PLANNING CONSULTATION RESPONSE

| Application No | 2025/1032 |
| Proposal | Single storey side extension and dropped kerb. |
| Address | 102 Manchester Road, Thurlstone, Sheffield, S36 9QW |

PROPOSED PLANS & ELEVATIONS

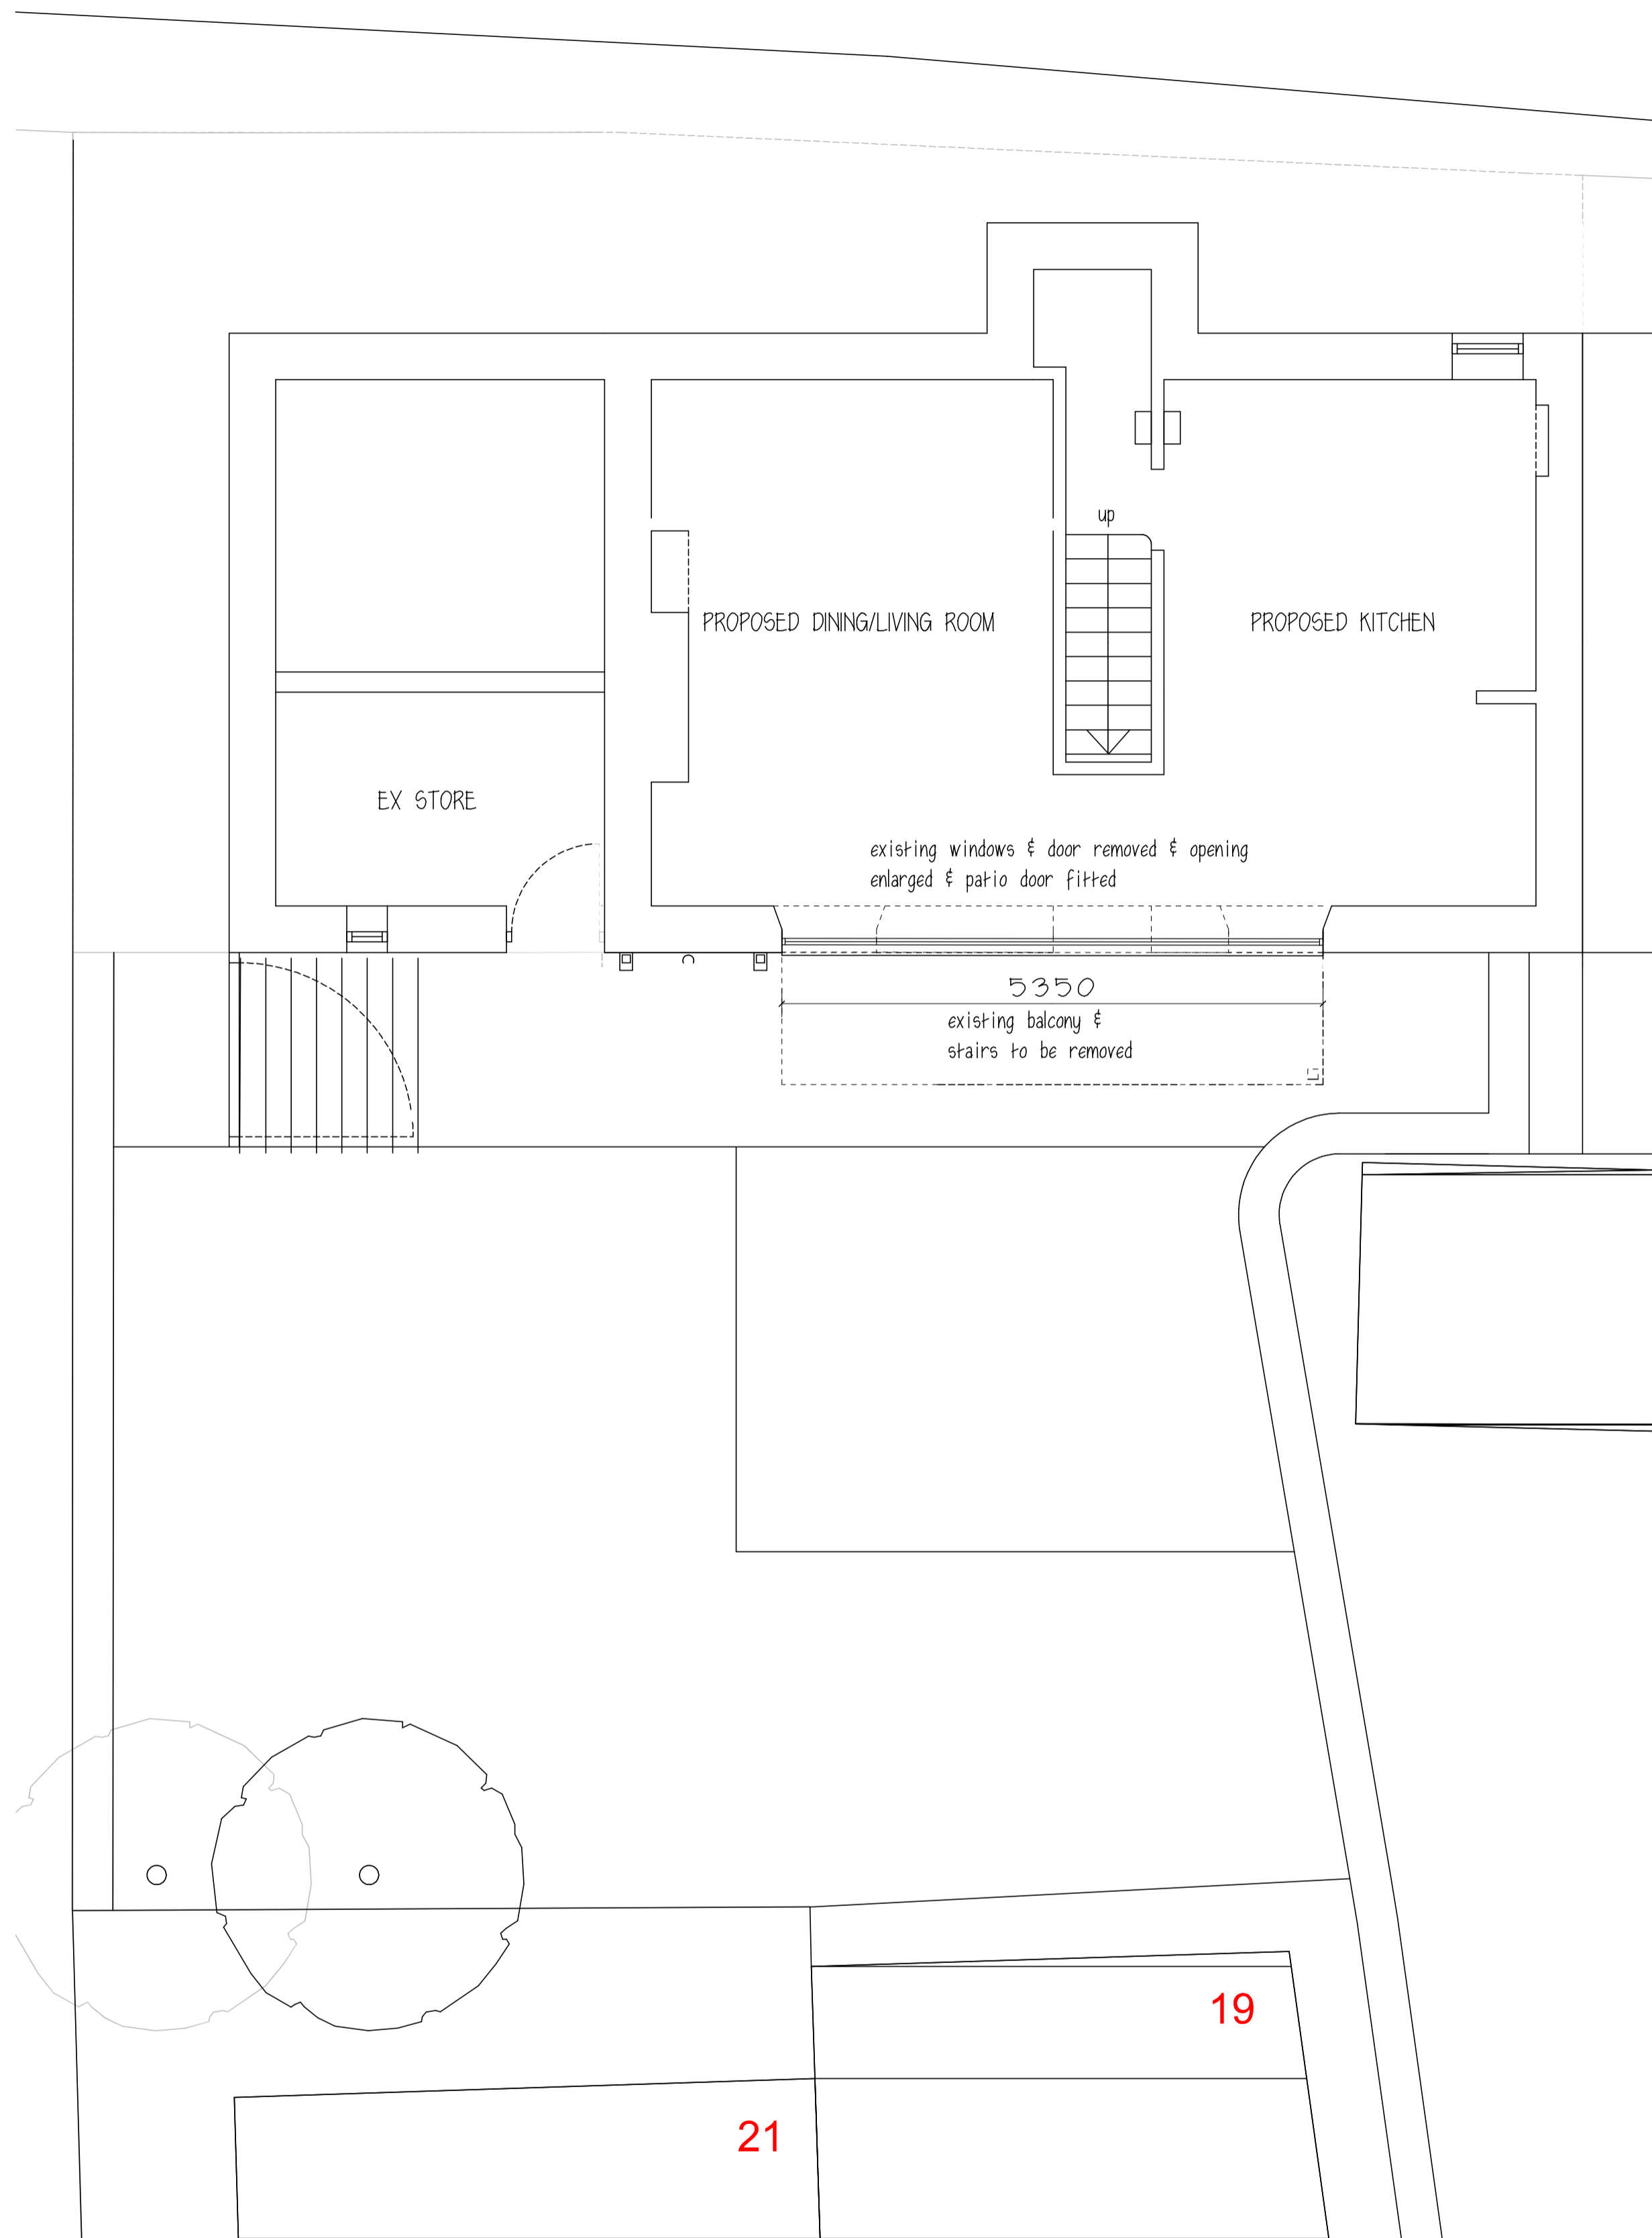
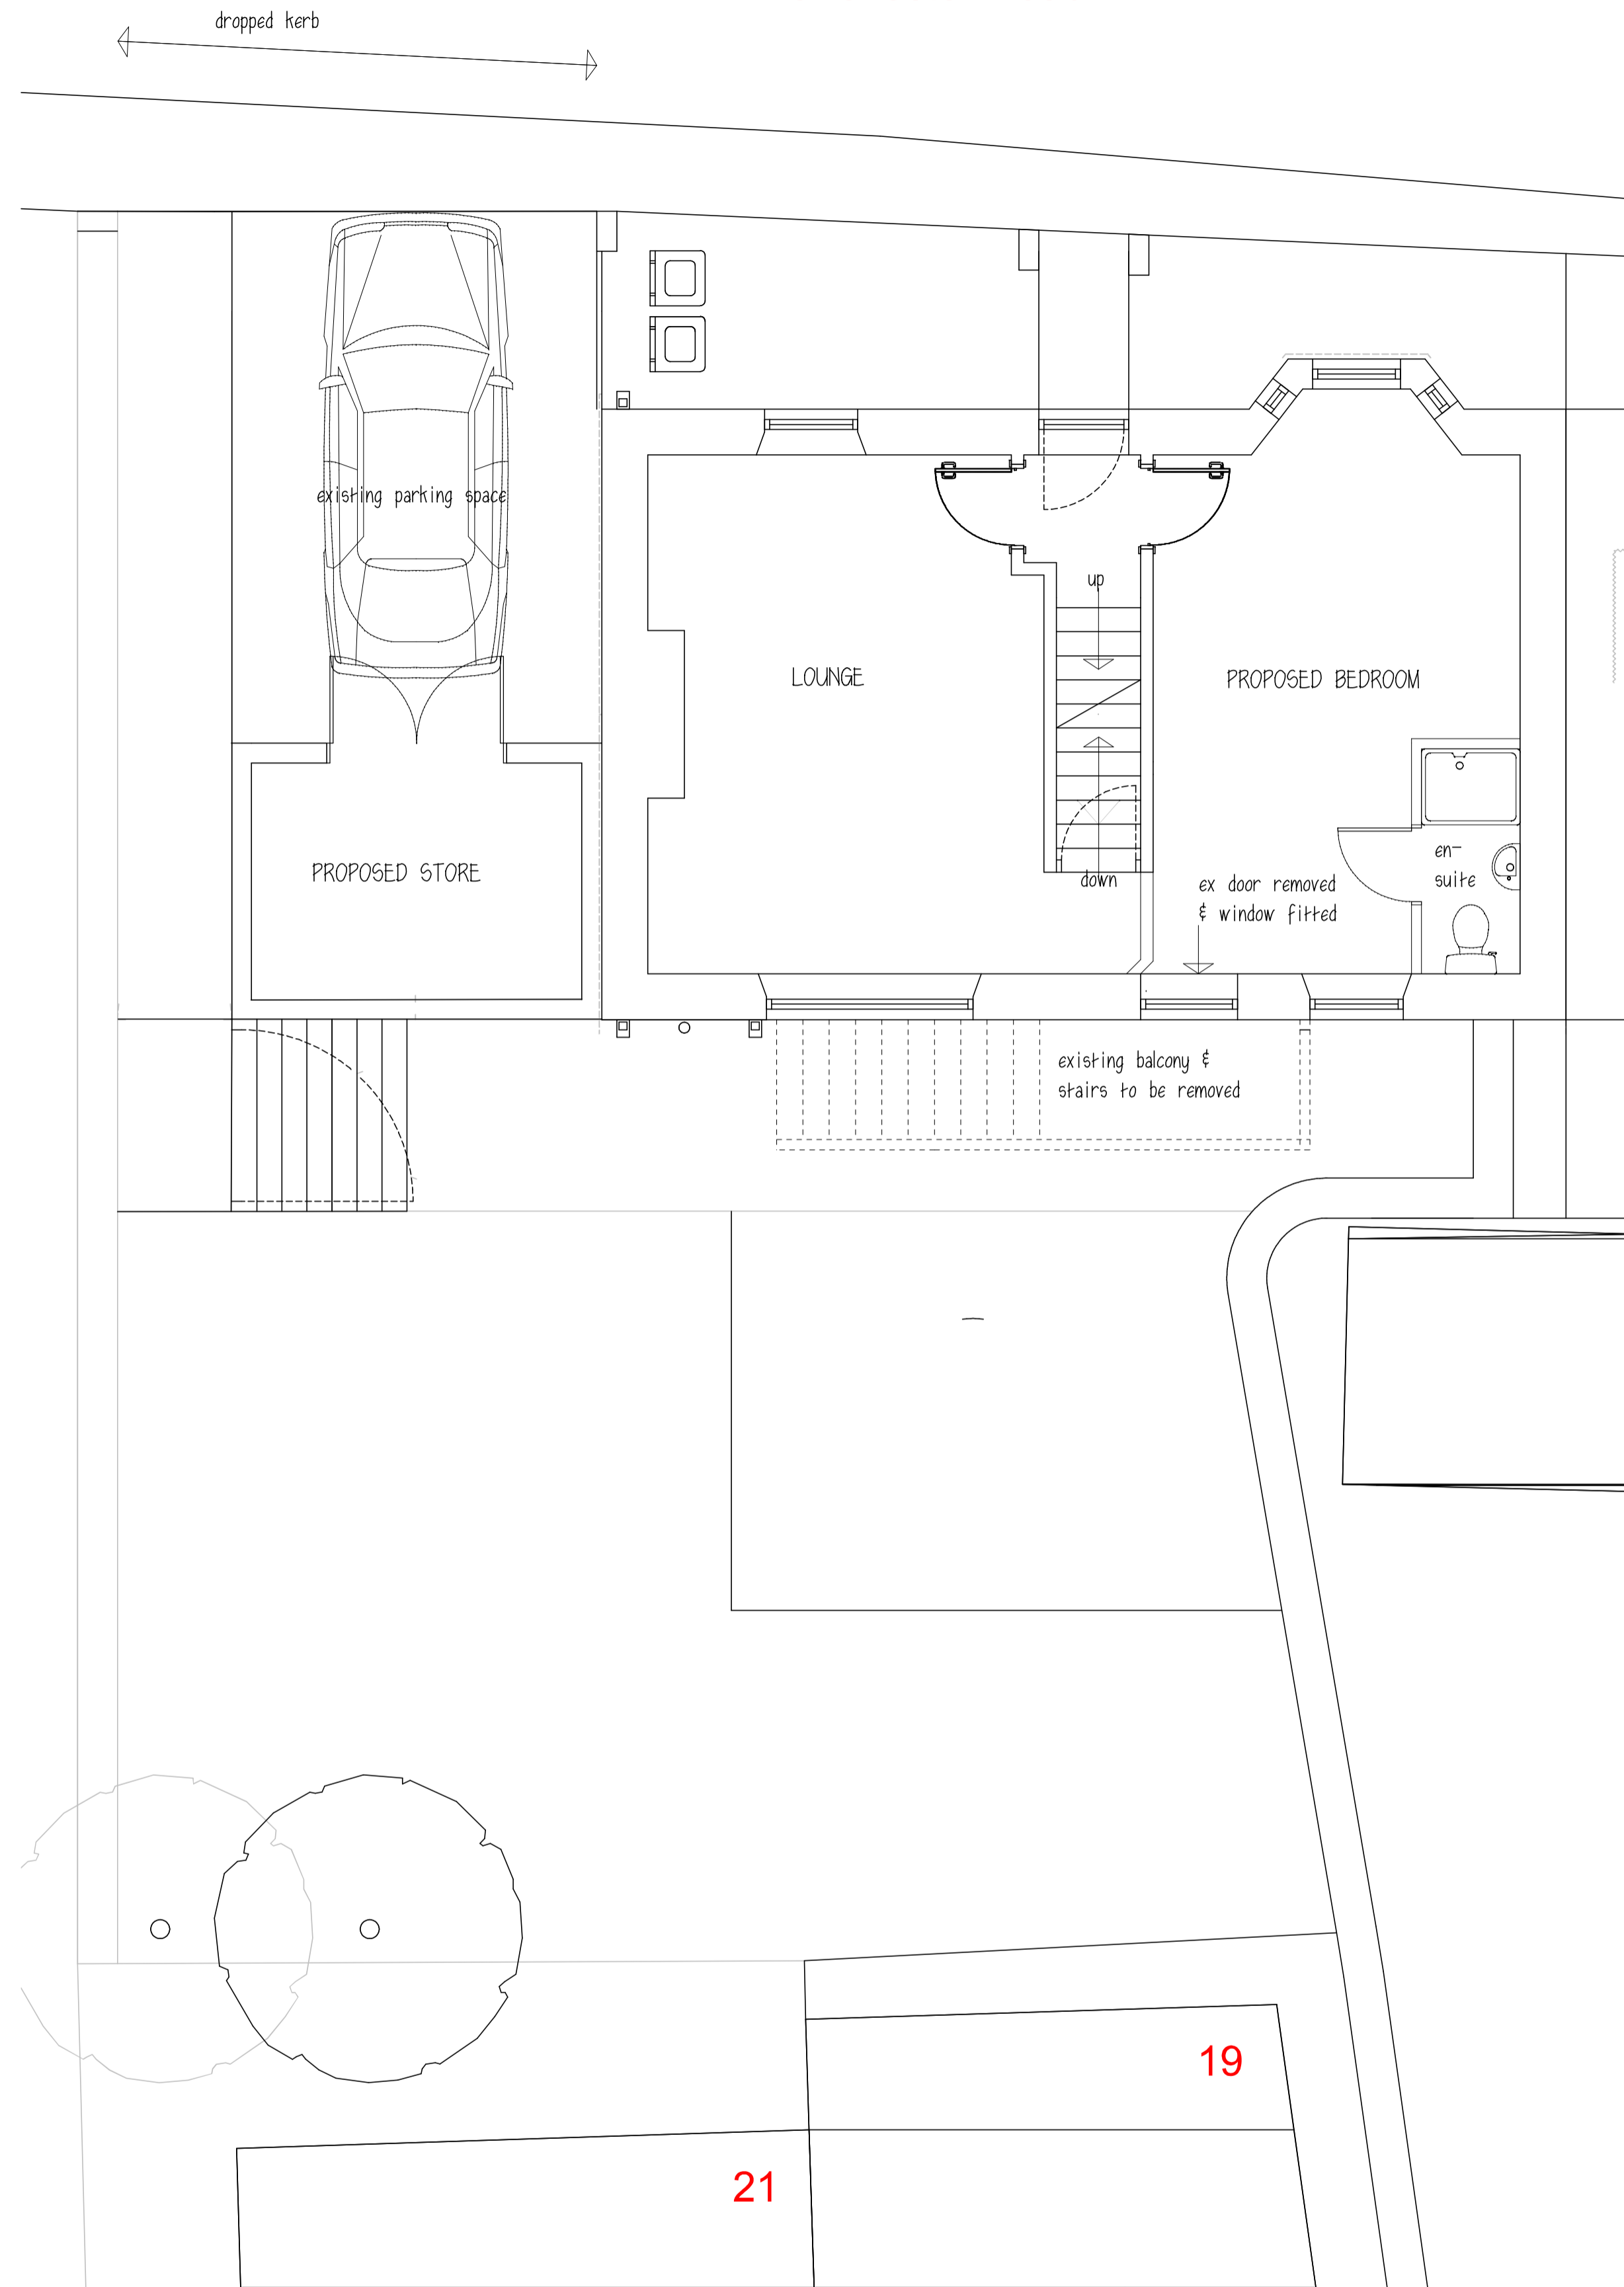
In principle, there are no significant conservation objections to the proposed works. However, to ensure that the development conserves the character and appearance of the building and the wider conservation area, the following conditions are recommended in relation to the proposed single-storey side extension:

- The facing stone shall match the existing building in terms of colour, size, type of stone, face dressing.
- The roof covering shall match the existing roof in terms of colour and appearance.
